Development Hearing Officer (DHO)
City of Albuquerque, Planning Department
Plaza Del Sol, 600 Second NW
Albuquerque, New Mexico 87102
November 5, 2025

RE: PROJECT – PRELIMINARY PLAT - PR-2025-020092, VOLCANO CLIFFS UNIT 26

Please find below the verbatim review comments received as part of the Sketch Plat process for the above-referenced project. Each comment is grouped by reviewing department and is followed by a placeholder for the applicant's response. The Sketch Plat meeting was held on 8-6-25.

Compiled Sketch Plat Review Comments with Applicant Responses

PASEO AND KIMMICK EAST
ALBUQUERQUE, NM
CONCEPTUAL GRADING
AND DRAINAGE PLAN

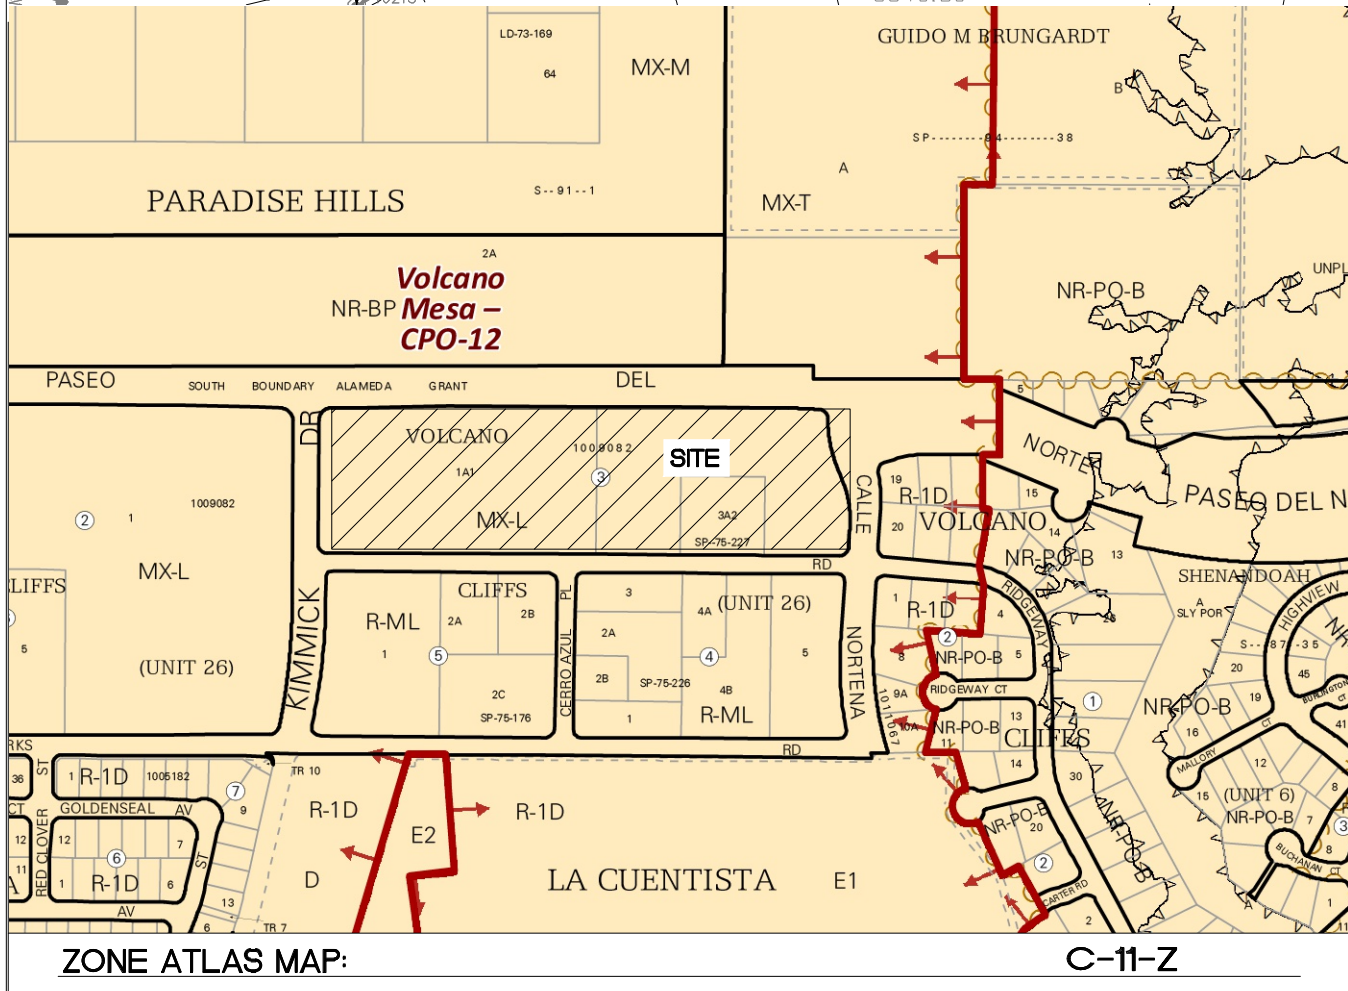
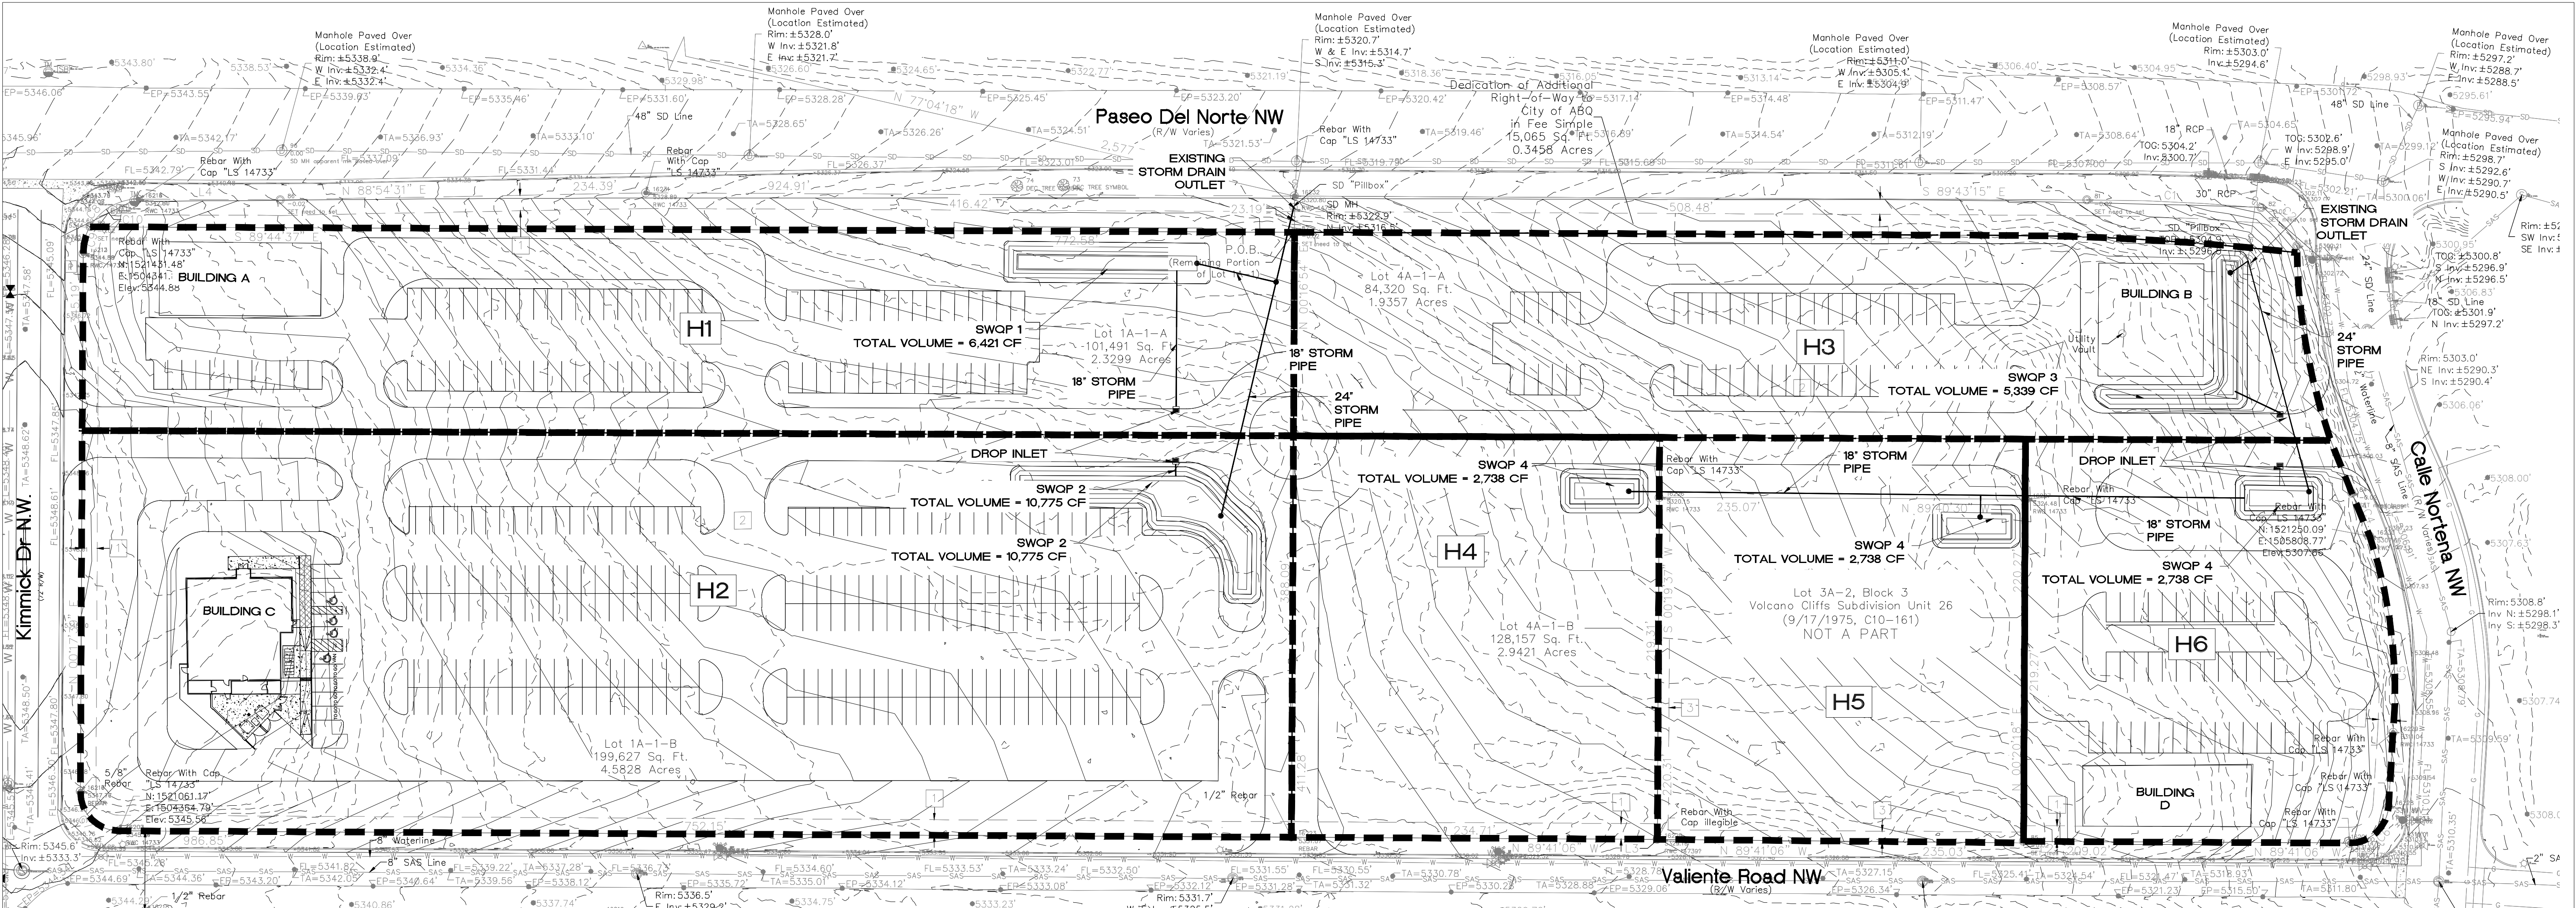
- Comment: Hydrology needs to approve the Conceptual Grading & Drainage Plan prior to approval of the sketch plat.

Applicant Response: Attached to this application is the approved G&D plan.

CSI-CARTESIAN SURVEYS INC.
P.O. BOX 44414 RIO RANCHO, N.M. 87174
Phone (505) 896 - 3050 Fax (505) 891 - 0244
cartesianbrian@gmail.com
Sheet 2 of 4
251082

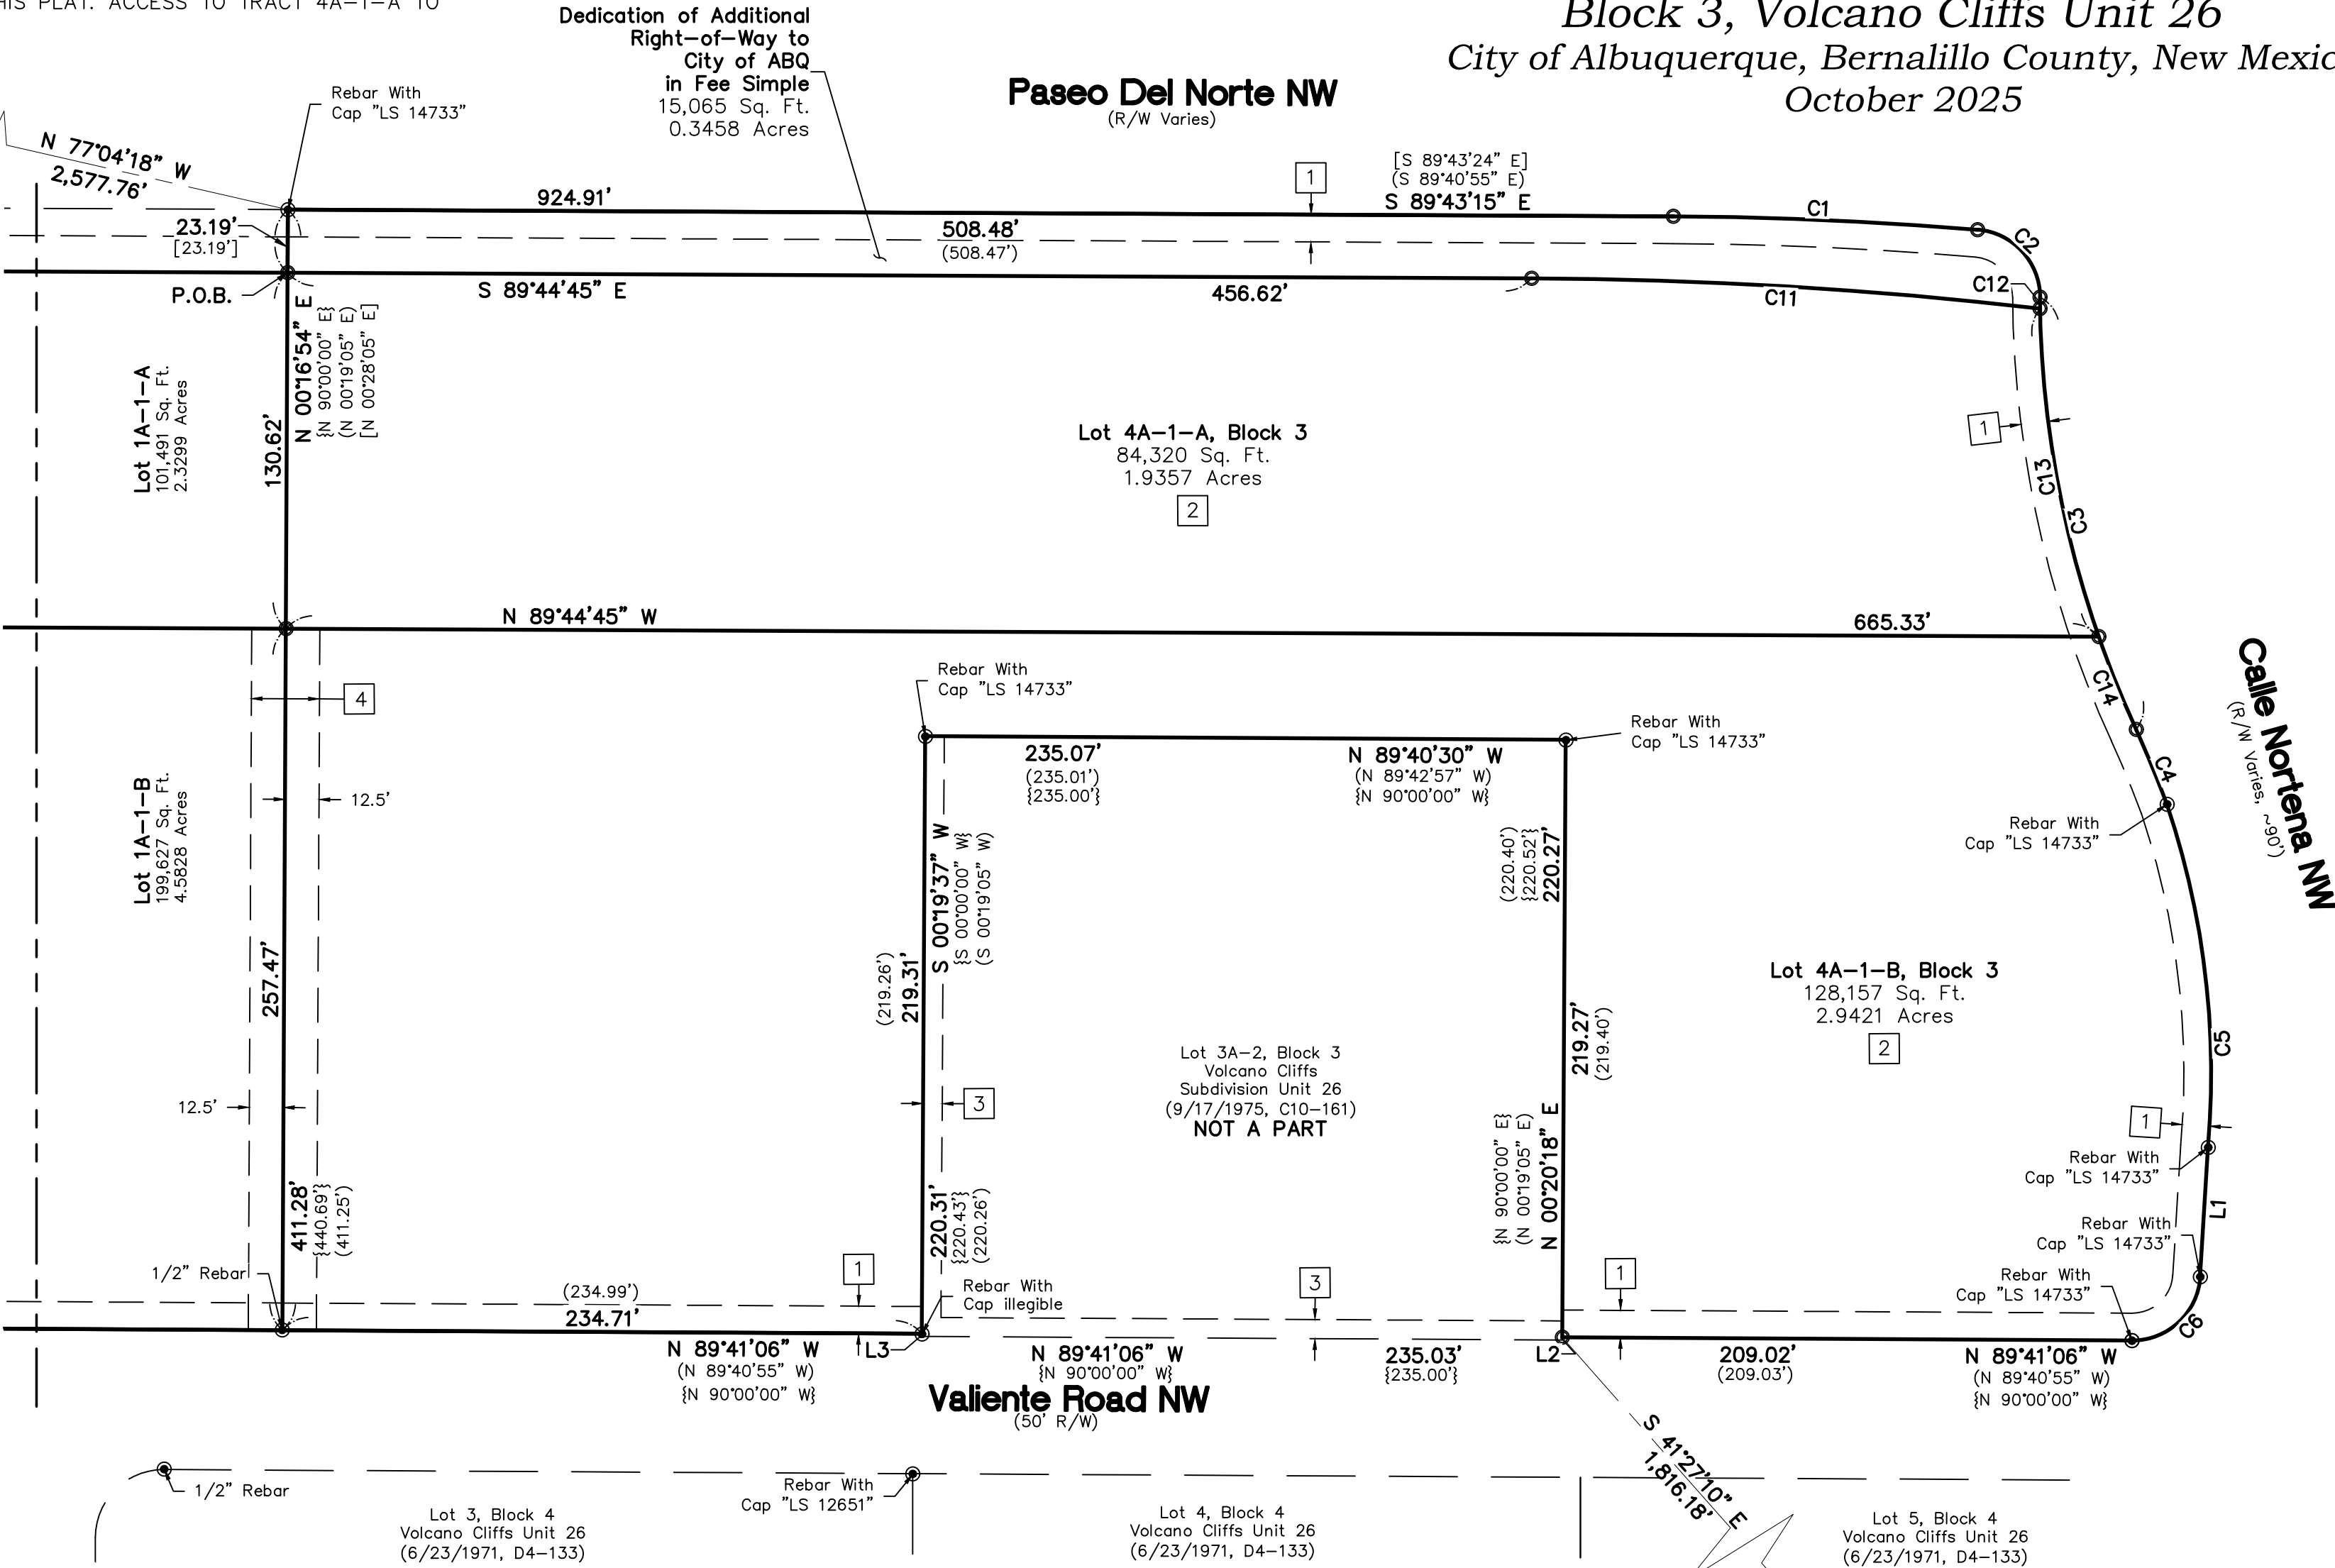
- Comment: As proposed, Lots 4A1A and 1A1A do not have all frontages with access to both water and sanitary sewer infrastructure.

- Comment: Exclusive public water and sanitary sewer easements are required for all public lines that are to be constructed outside of any dedicated rights-of-way. A minimum width easement of 20' is required for a single utility and 25' for water and sewer both within the same easement.

- Comment: The surveyor shall field verify the location of existing private water and/or private sanitary sewer services to determine if private service easements are needed.

- Comment: Proper private water and/or private sanitary sewer service easements shall be granted for access to public waterline and/or public sanitary sewer for proposed lots which do not have direct access.

Applicant Response: 4A-1-A will access water and sewer from Calle Norte road. 1A-1-A will access sewer from the new proposed 20' private sewer easement (Easement 4 on the plat). Water will be accessed off of Kimmick Road. Please see conceptual Utility plan for reference.

Applicant Response: A new proposed 20' private sewer easement (Easement 4 on the plat) will be granted with this plat.

Applicant Response: Completed and a new proposed 20' private sewer easement (Easement 4 on the plat) is being proposed on this plat.

Applicant Response: 4A-1-A will access water and sewer from Calle Norte road. 1A-1-A will access sewer from the new proposed 20' private sewer easement (Easement 4 on the plat). Water will be accessed off of Kimmick Road. Please see conceptual Utility plan for reference.

Drawing file: PR-2025-020092_MAJOR_PLT-2025-00016_December_17_2025 (PP) / Sidewalk Exhibit-2025-11-07-05 - Site Sketch_v1.pdf

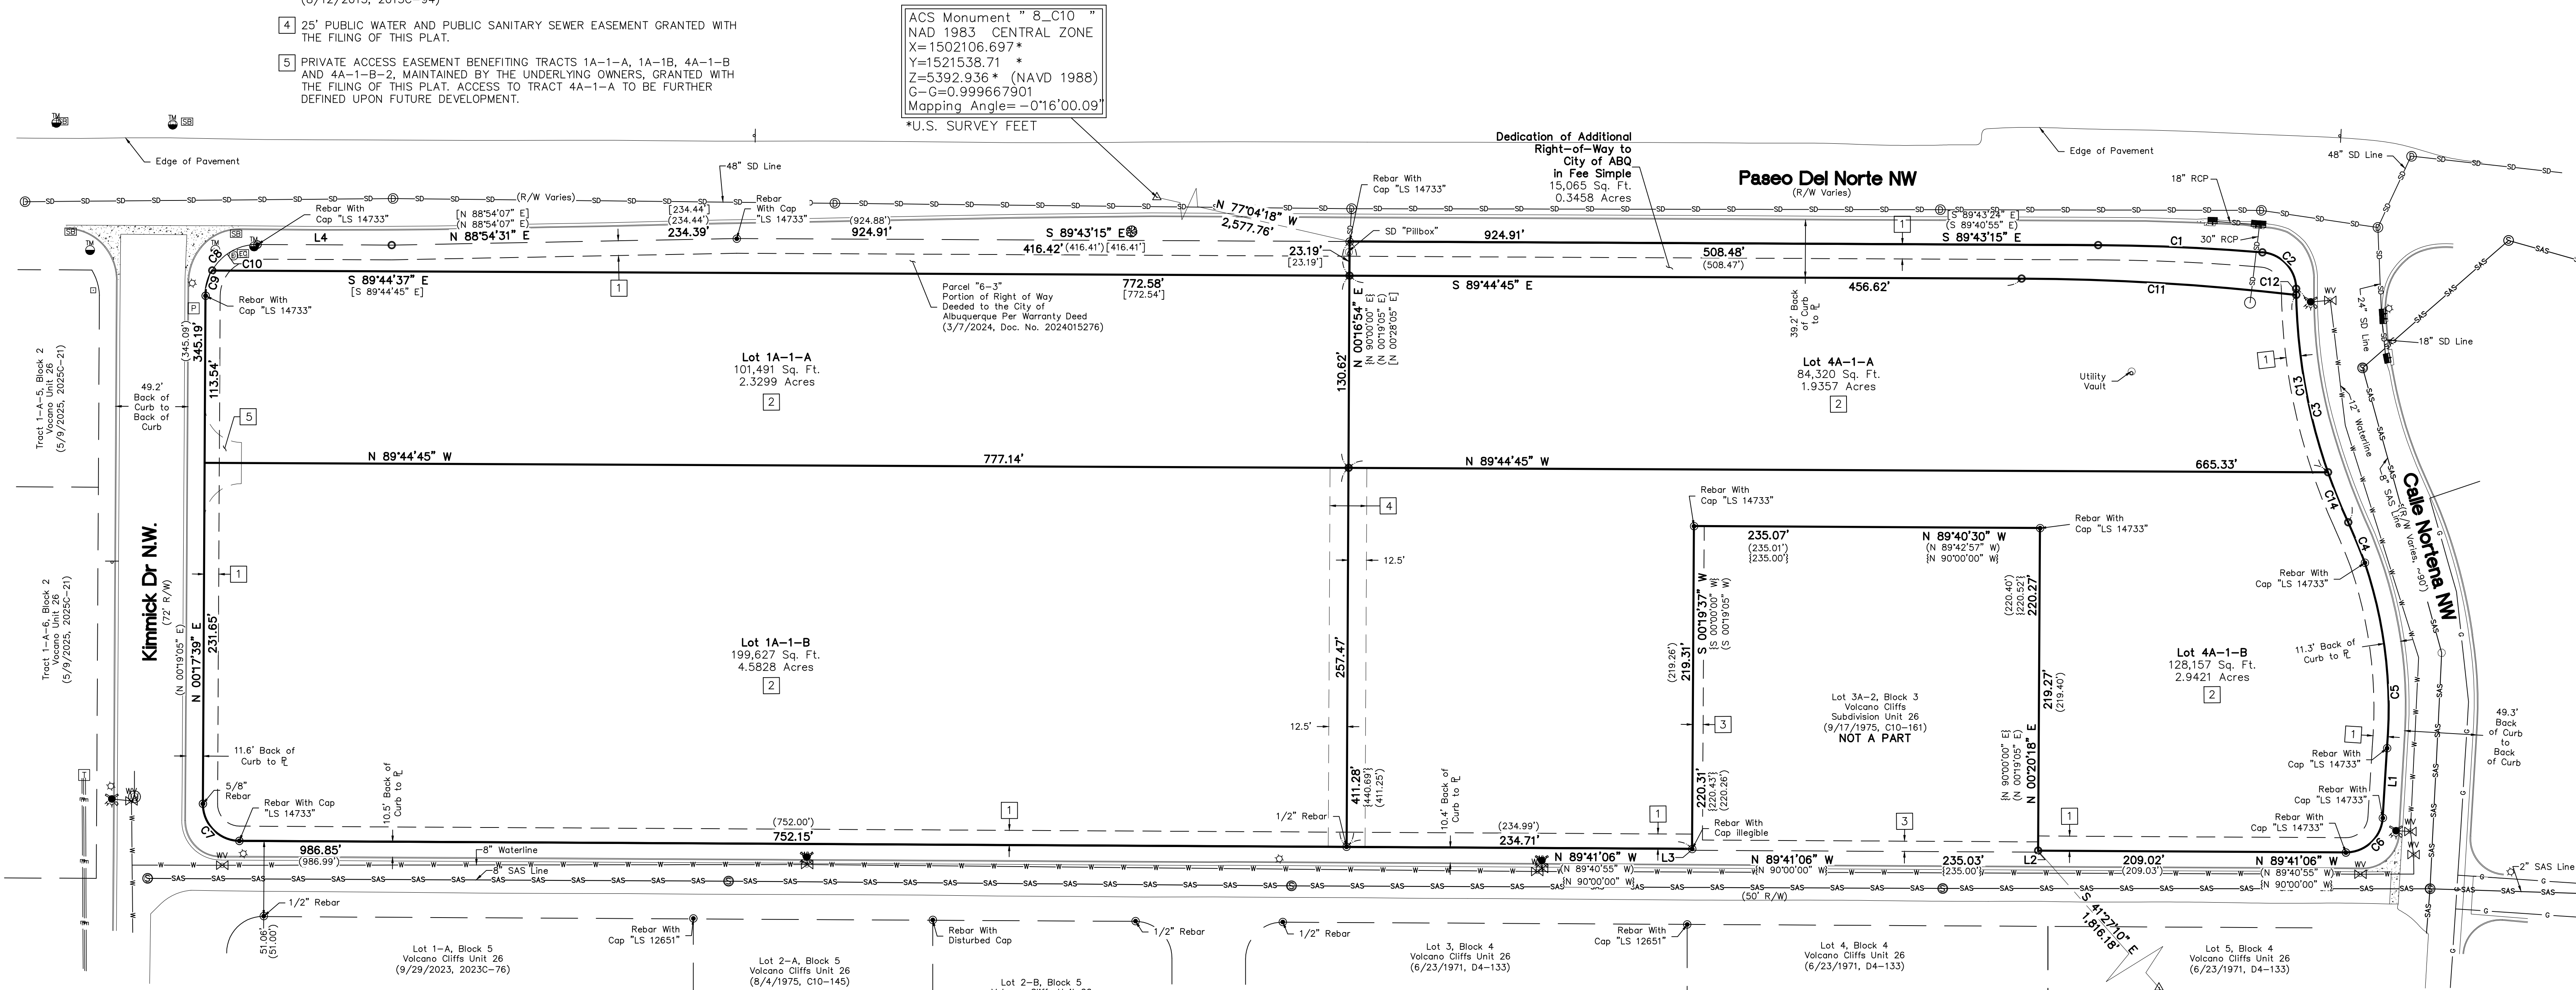
- Comment: Paseo Del Norte is a Principal arterial requires 6 ft sidewalk, and 5-6 ft Landscape buffer. Kimmick is a proposed minor collector requires 6 ft sidewalk, and 5-6 ft Landscape buffer. Valiente, is a local street requires 5 ft sidewalk, and 4-6 ft Landscape buffer. Calle Nortena is a proposed major collector and requires 6 ft sidewalk and 5-6 ft Landscape buffer.

- Comment: Demonstrate compliance with Section 7 of the DPM, Table 7.2.29, regarding Sidewalk width requirements and its landscape buffer.

Paseo del Norte is classified as a Principal Arterial Street and a requires a 6-foot sidewalk width and a 5–6-foot landscape buffer. Valiente Rd. is a local street requires a 5ft sidewalk width and a 4-6 landscape buffer.

Applicant Response: An IL has been included in this application that includes the required sidewalks. We applicant has not proposed a sidewalk along Paseo as it has been included in an existing City Work order project.

Applicant Response: An IL has been included in this application that includes the required sidewalks. We applicant has not proposed a sidewalk along Paseo as it has been included in an existing City Work order project.
